From: Nicola Spencer
Sent: 25 April 2017 12:00
To: [REDACTED]
Subject: FW: Further Information Required on Your Ref: N/A Our Ref: BE/41/17/HH

NLPG UPRN 100062237016

Location Plan scale 1 : 1250

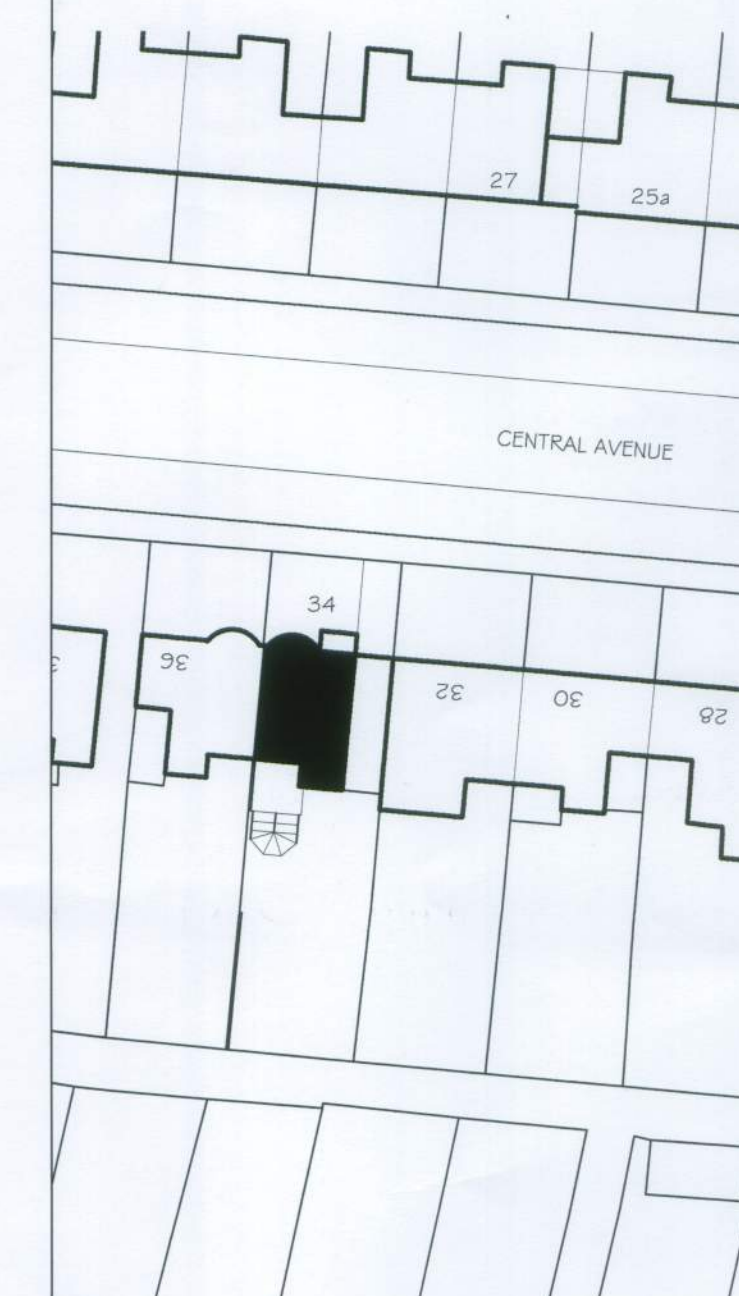
The copy that was scanned had not been red edged but I have arranged for the colour copy we have to be scanned, so this resolves the issue of the red edge on the location plan.

Site Plan scale 1 : 500

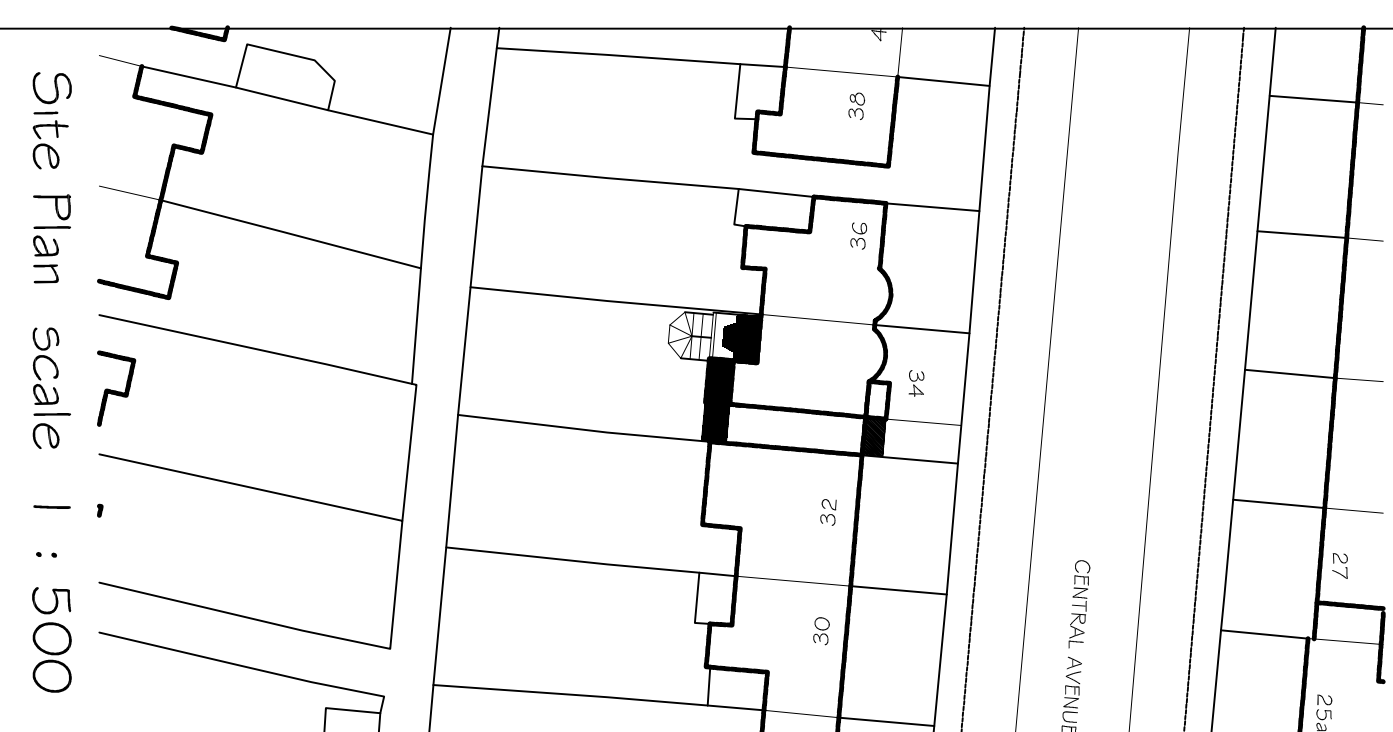
With regard to the distances to the boundary it appears that the ground floor extensions run up to the side boundary so I only require the distances from the proposed ground floor extension to the rear boundary and the distance between the proposed garage extension to the front boundary

On receipt of the amended block plan showing the dimensions to the boundaries we will be pleased to validate your application
